Re: Planning Application 18/0432

Address: SPEED PARLOUR CHATBURN ROAD, CLITHEROE BB7 2AP

Description: CHANGE OF USE FROM SUI GENERIS TO A5 (HOT FOOD TAKEAWAY) ASIAN STREET FOOD DELI.

Drawing Title		
PROPOSED PLANS & ELEVATIONS		
Scale	Date	Drawn
Varolus @ A2	MAY 2018	NE

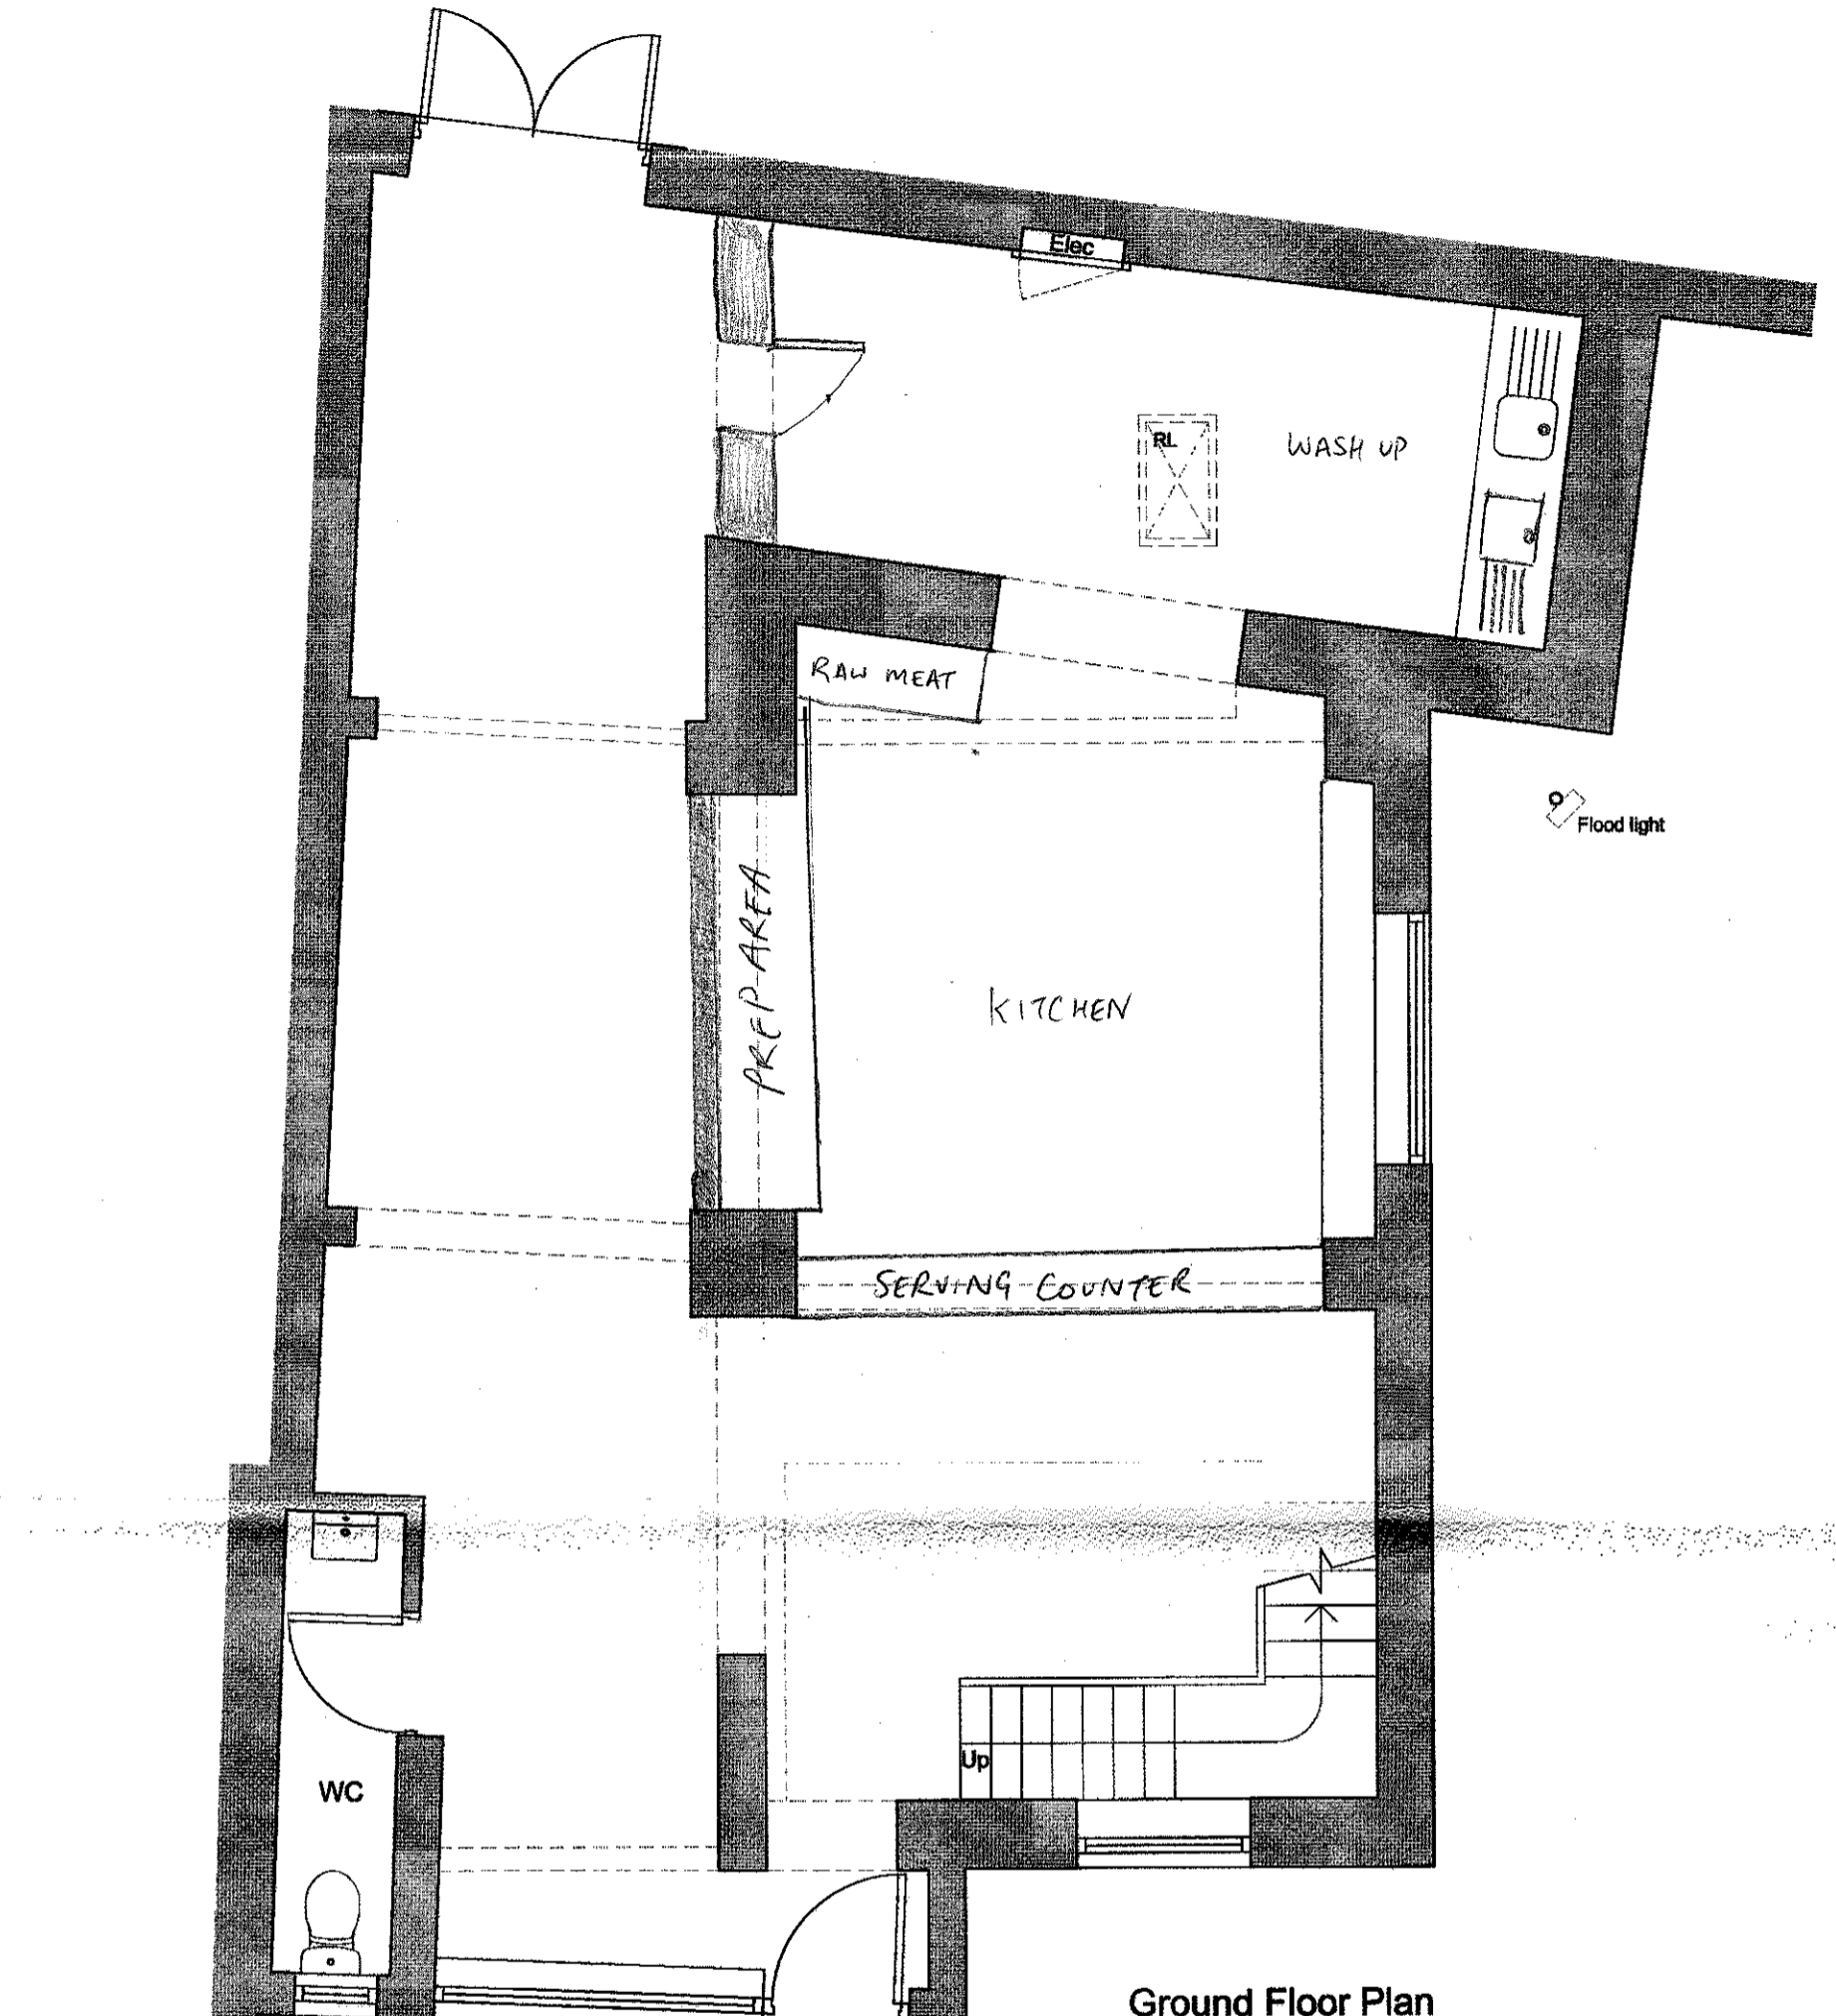
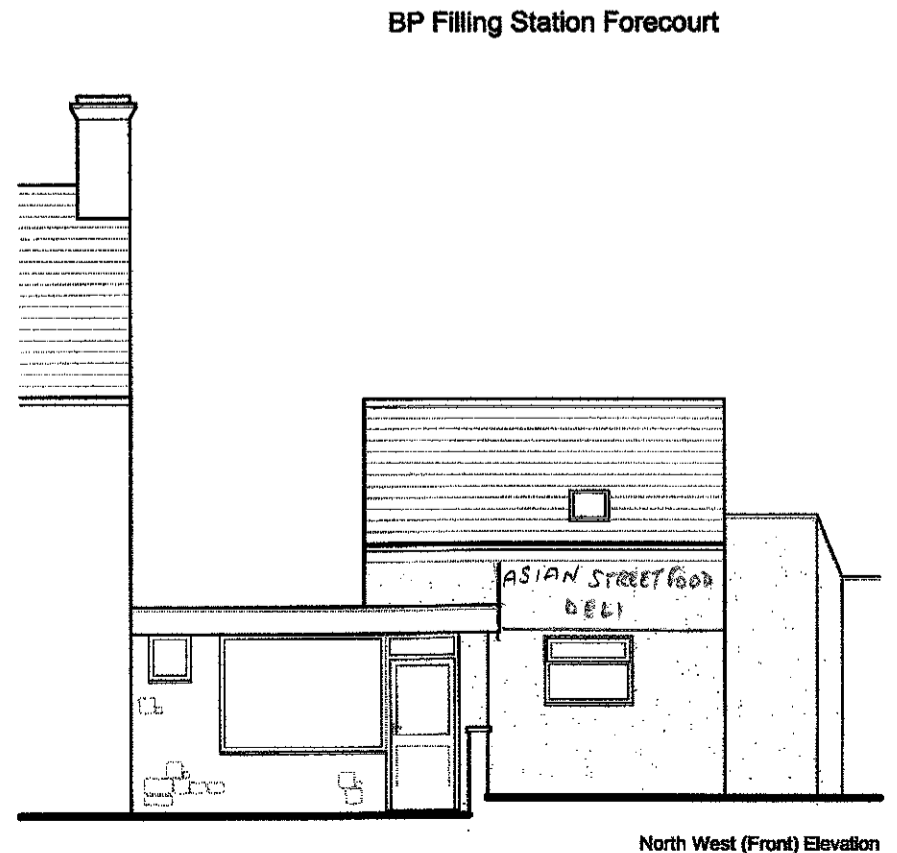
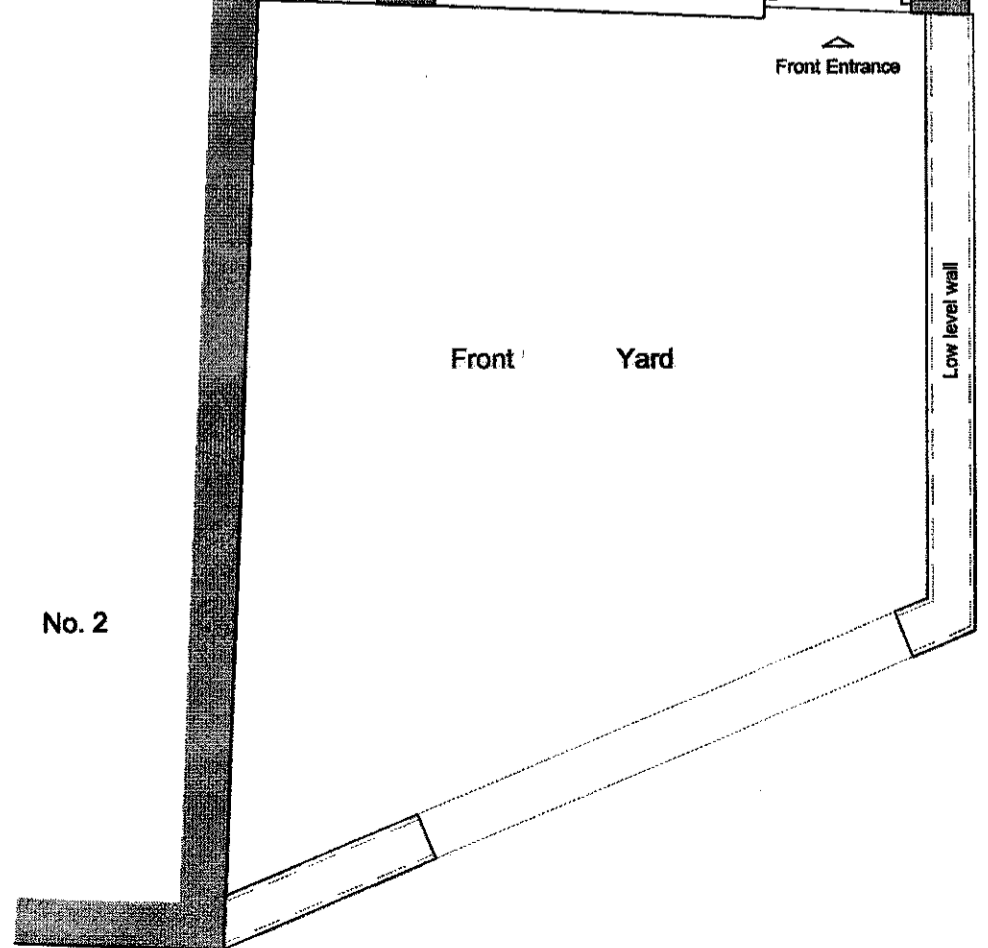
It should be noted that the forecourt at the front of the shop may be used as external seating, any such provision including any waste bins should be confined to the shop curtilage and impede the garage forecourt.
